Our ref: OUT26/8340

Your ref: SSD-89050708

Subject: Mixed Use Development, Corner of Union and Kenrick Streets, The Junction (SSD-89050708) (Newcastle City) – Environmental Impact Statement (EIS)

Appendix A - Detailed advice to DPHI Planning & Assessment regarding the Mixed Use Development, Corner of Union and Kenrick Streets, The Junction (SSD-89050708) (Newcastle City) – Environmental Impact Statement (EIS)

REVISION	R.10 SSDA 04.05.2026
DRAWING	FLOOR PLAN LOWER BASEMENT
NUMBER	A-12

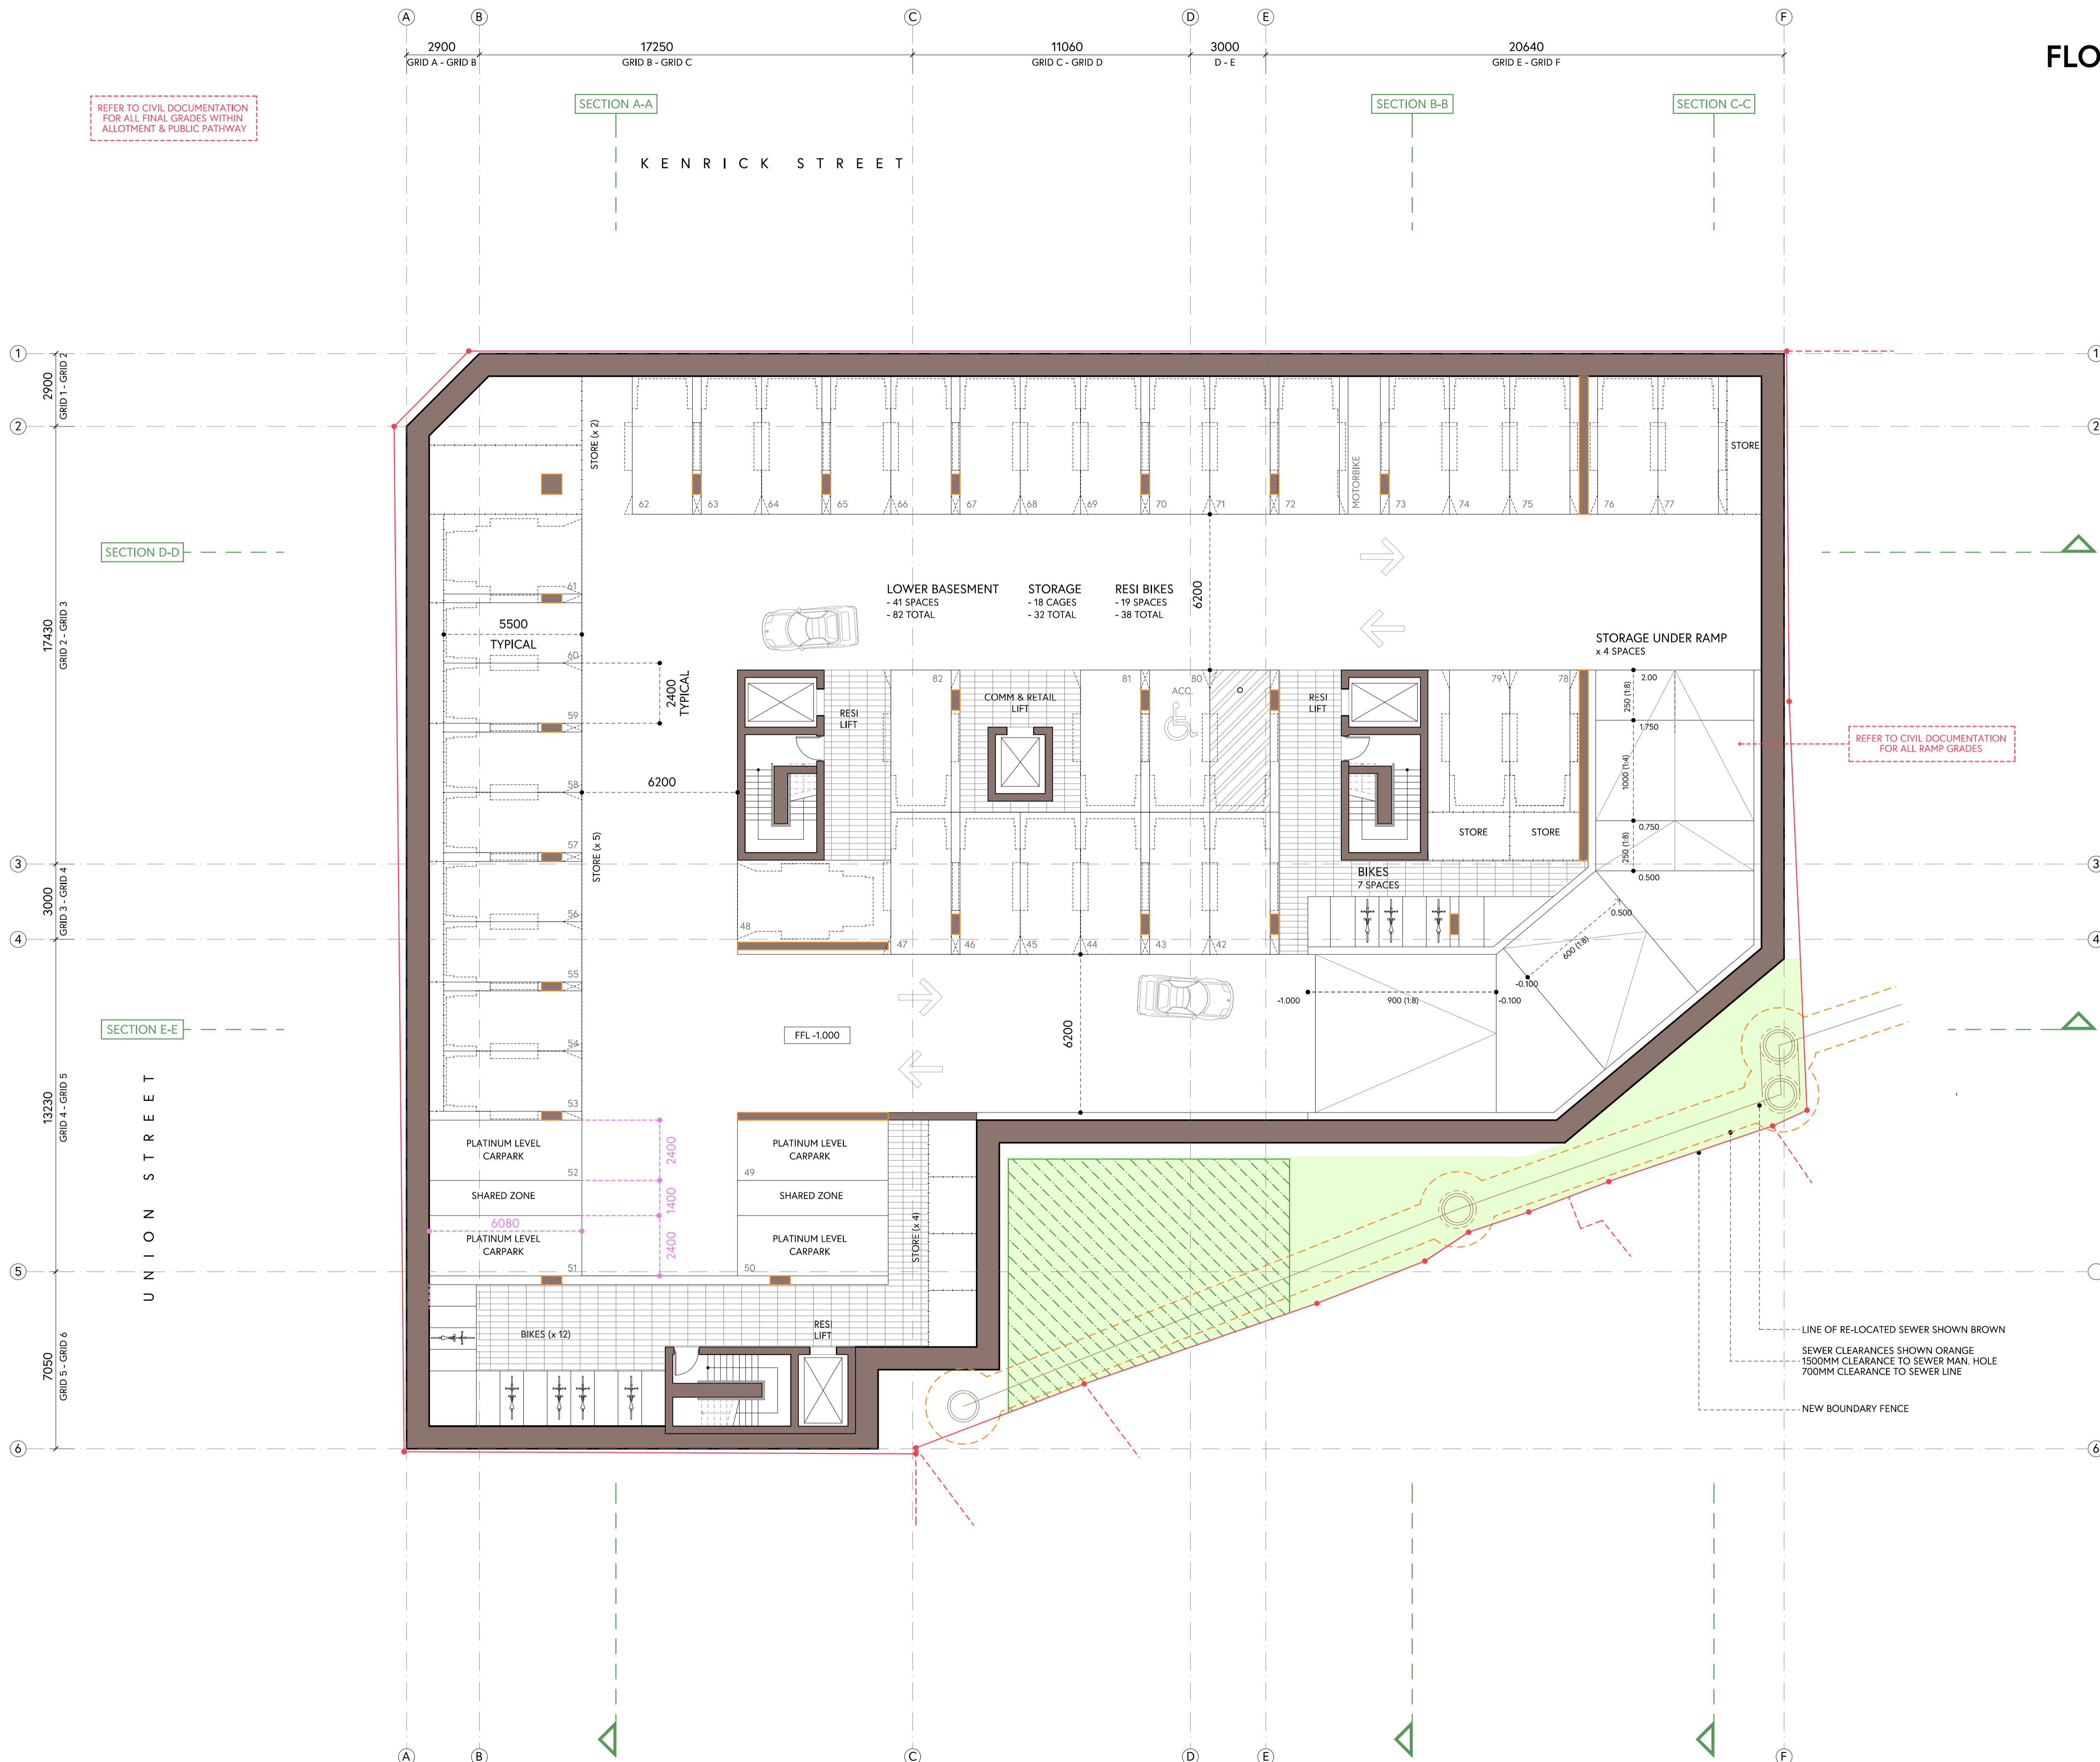
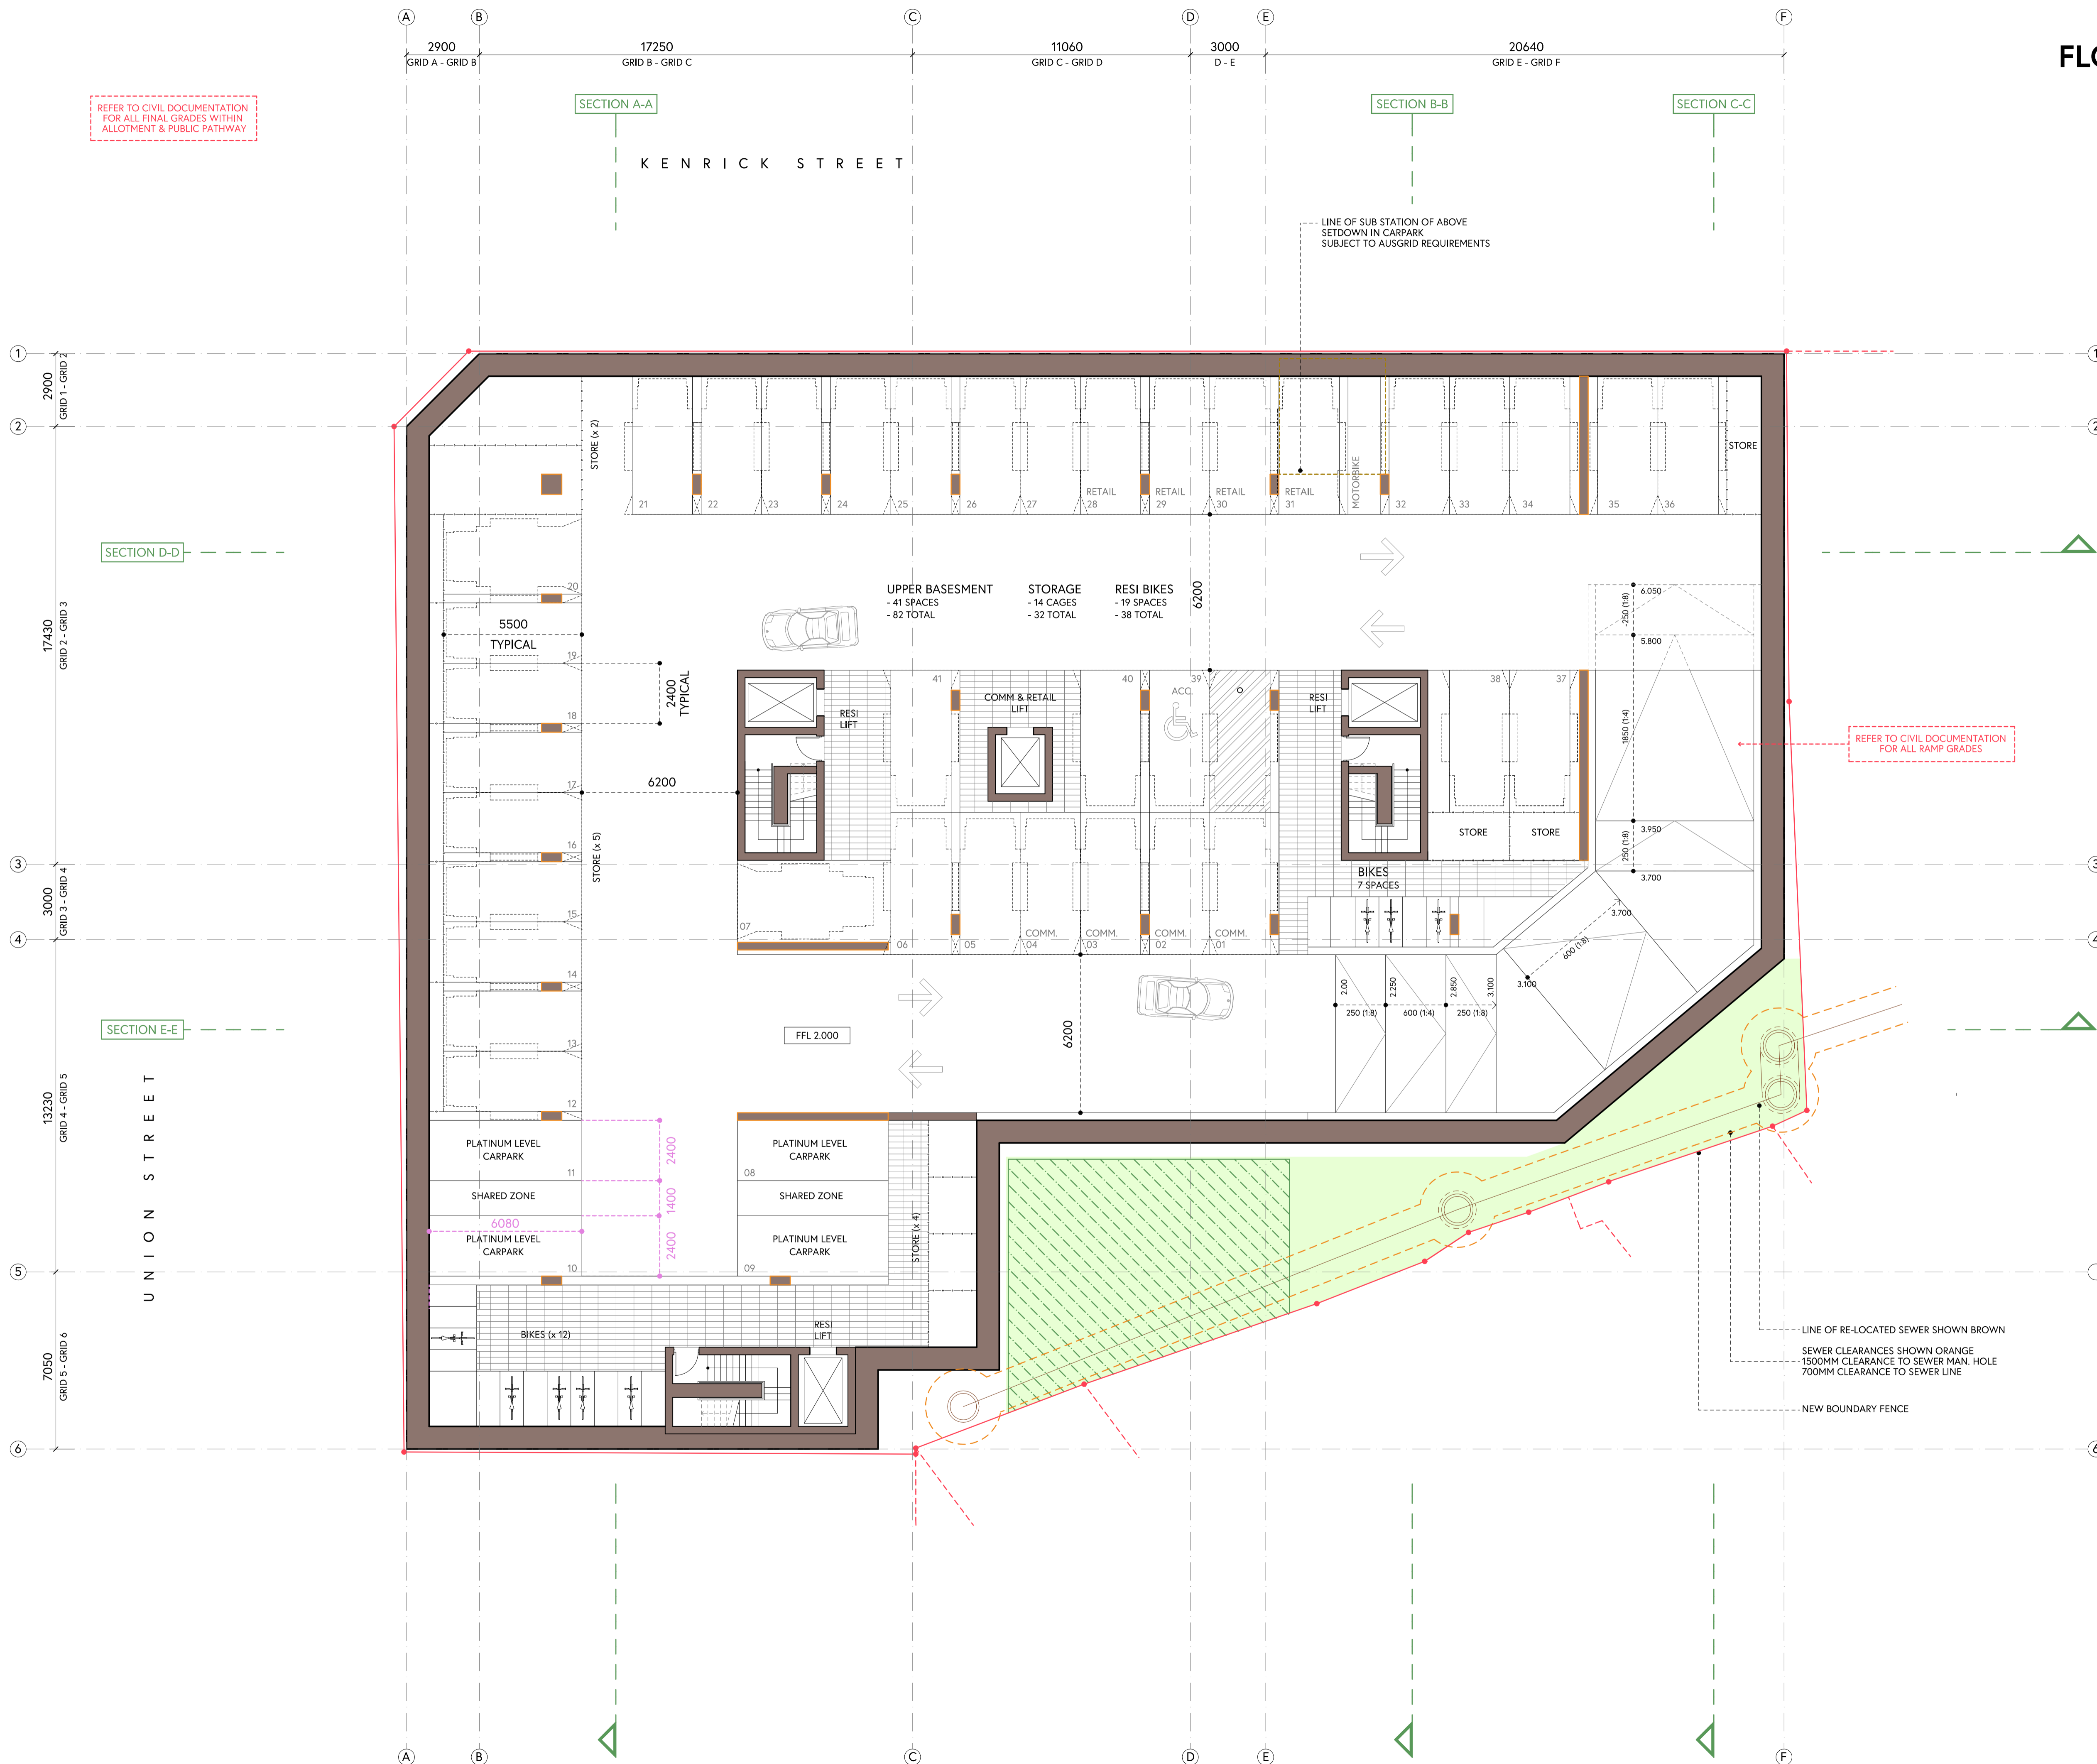
The Department of Planning, Housing and Infrastructure (DPHI) should request the proponent to clarify the basement design and quantify the maximum annual volume of water take due to aquifer interference activities during construction and operation. If the basement design is not confirmed, the volumes for multiple cases should be presented.

Insufficient information has been provided to confirm the potential groundwater inflow volumes. DCCEE Water notes that the groundwater table will be intercepted. Maximum excavation depths for this project will be up to 8m and groundwater was observed at 2.27m and 2.42m. Due to these estimates, groundwater seepage into the excavation is expected. The basement design is yet to be confirmed which creates uncertainty in the modelling inputs and the resulting inflow estimations.

Uncertainty is further identified from the use of only one monitoring well and observations limited to 2 samples within a week which is less than the minimum requirements. The preliminary inflow modelling has been based on no inflow from the shoring walls which represents a low inflow case and has provided inflow rates over time step periods rather than quantifying maximum annual inflow volumes. proponent has not presented sufficient information and analysis on inflows during the construction and ongoing operation of the site. Quantification of maximum potential inflow volumes is required.
